From: BCTAdmin@thameswater.co.uk
Sent: 27 April 2017 10:52
To: Planning
Subject: 3rd Party Planning Application - 6/2017/0624/MAJ

Our DTS Ref: 55053
Your Ref: 6/2017/0624/MAJ

Re: PLOT 5000, HATFIELD BUSINESS PARK, HATFIELD, HERTFORDSHIRE, AL10 9EZ

Drawing Title  
**PROPOSED LEVELS AND DRAINAGE STRATEGY PLAN**

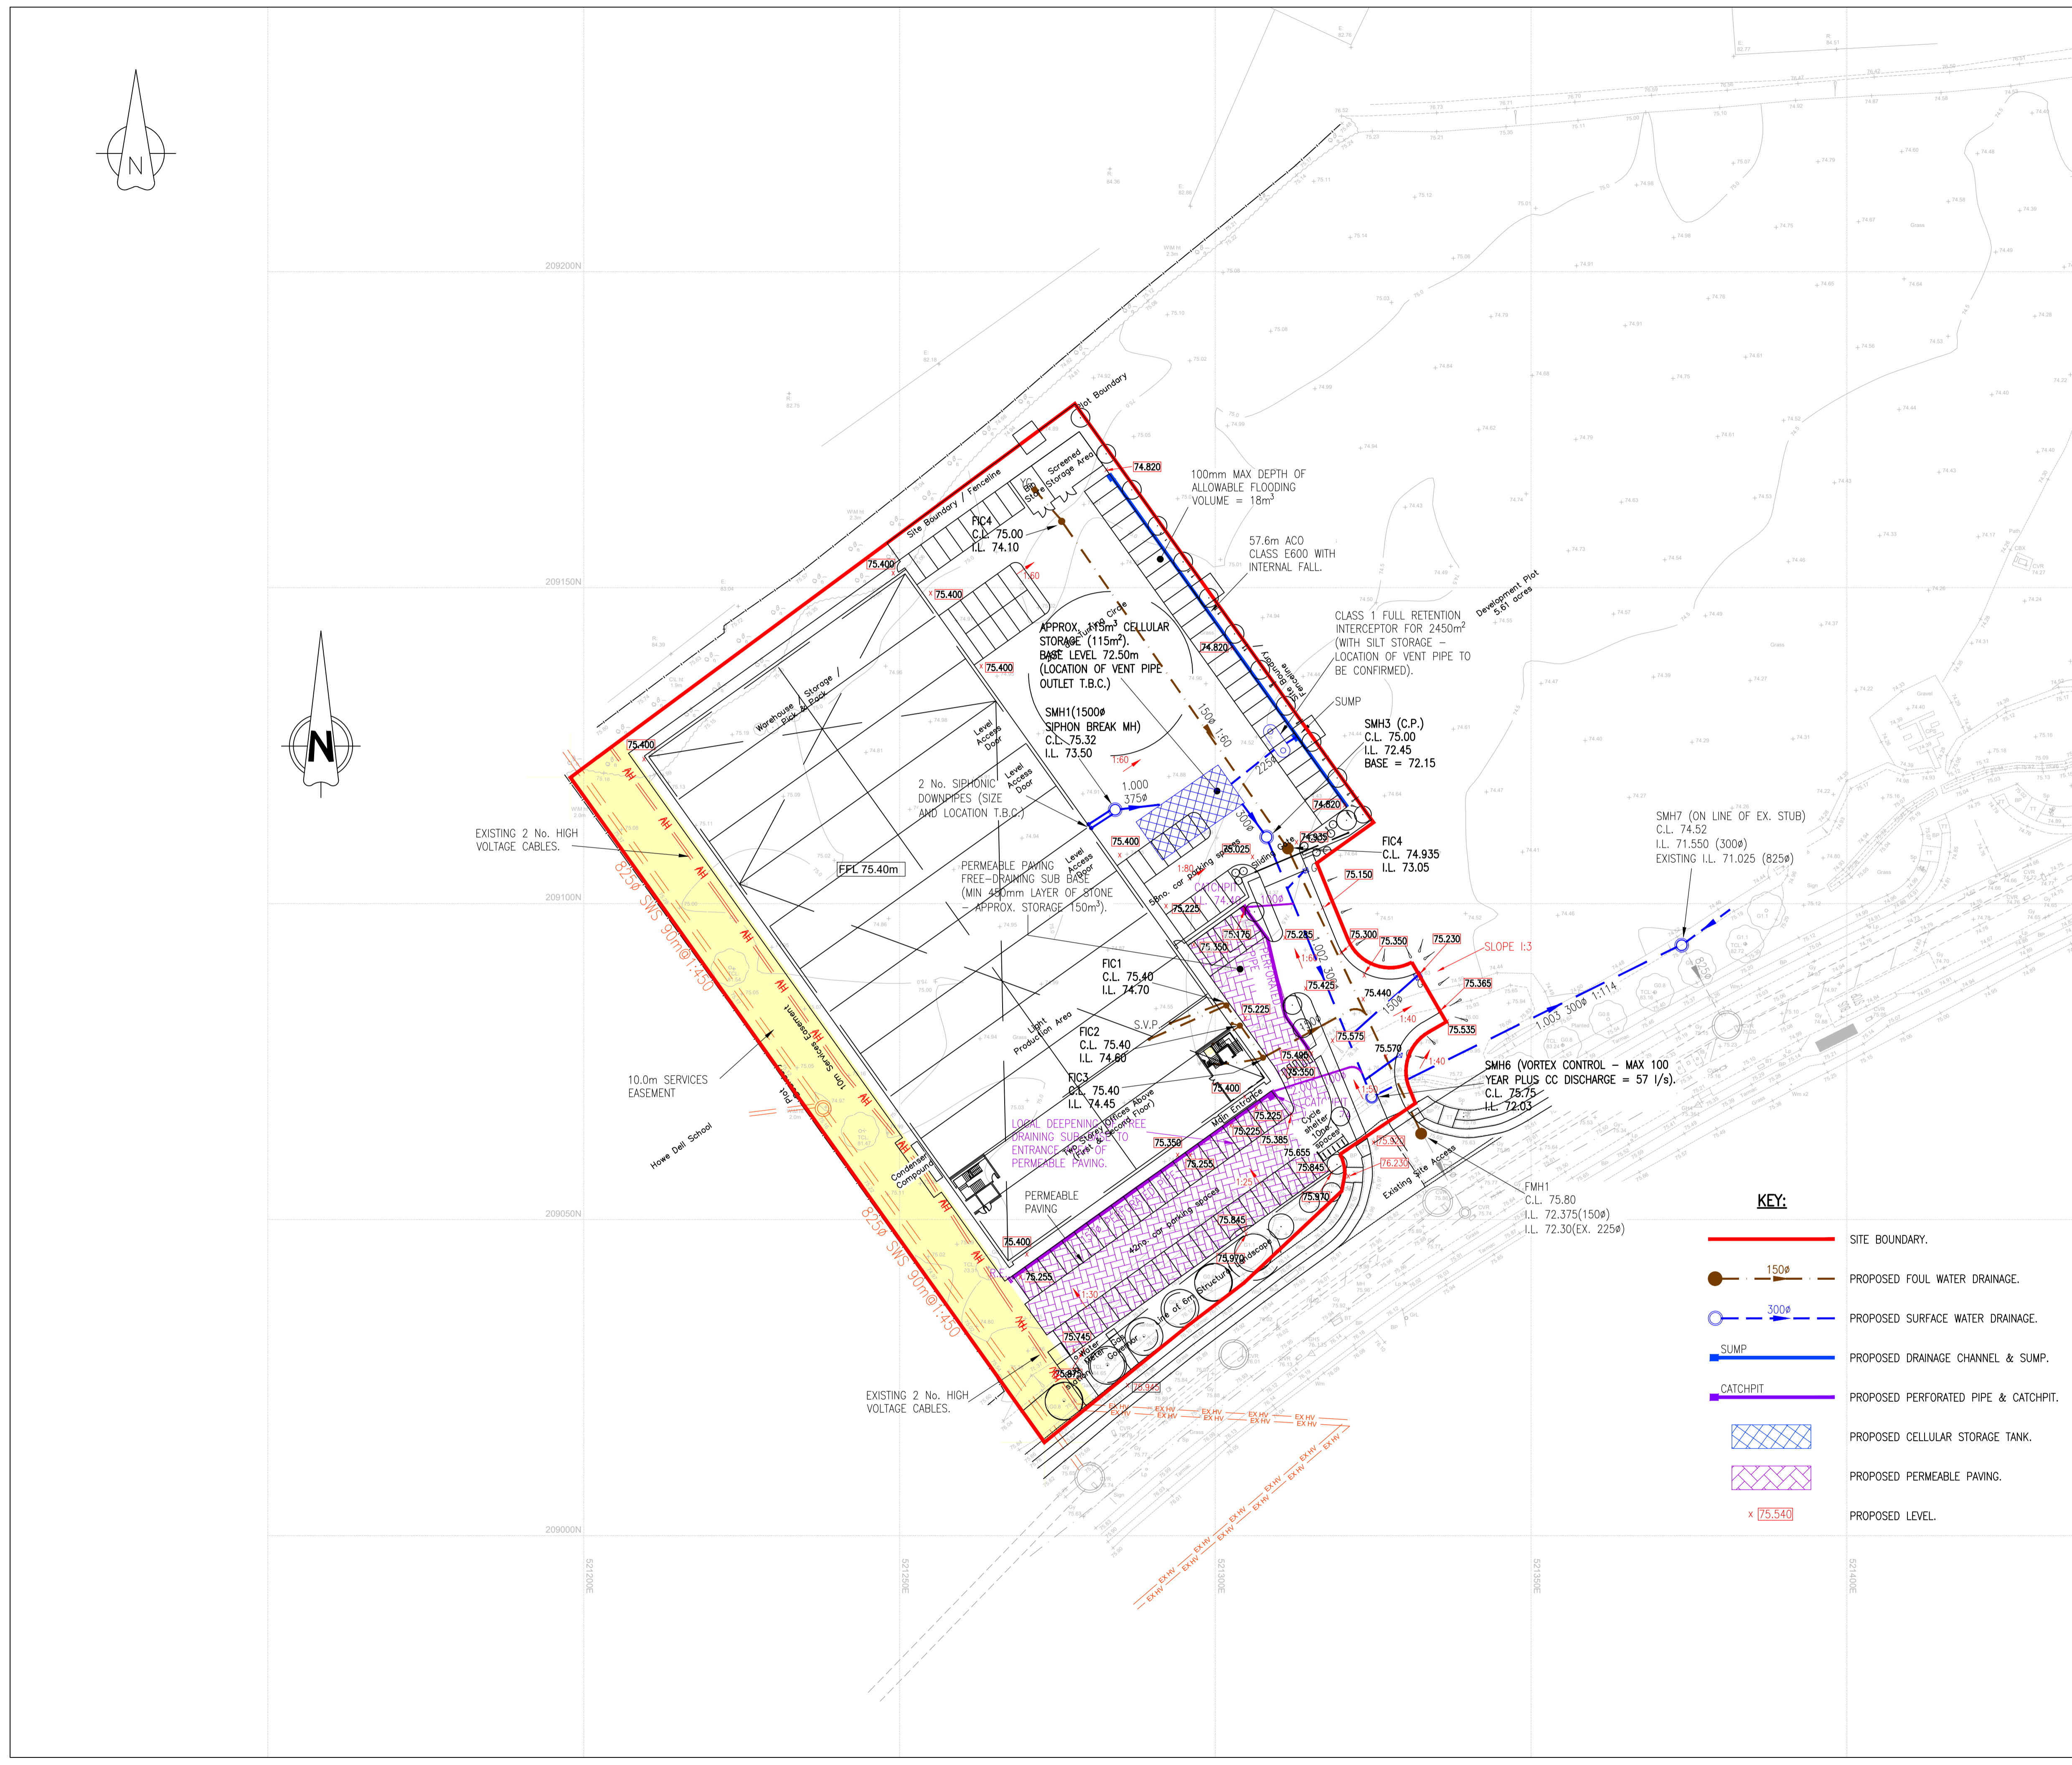
We have no objection to foul water proposal. Regarding surface water: controlling flow rates from sites should be based on Qbar which for this site is equal 2.04l/s. We can accept greenfield runoff rate for 1 in 100 years, which is equal 6.5l/s and not 57l/s. Please recalculate greenfield runoff rate using IH124 method and adjust drainage strategy accordingly.
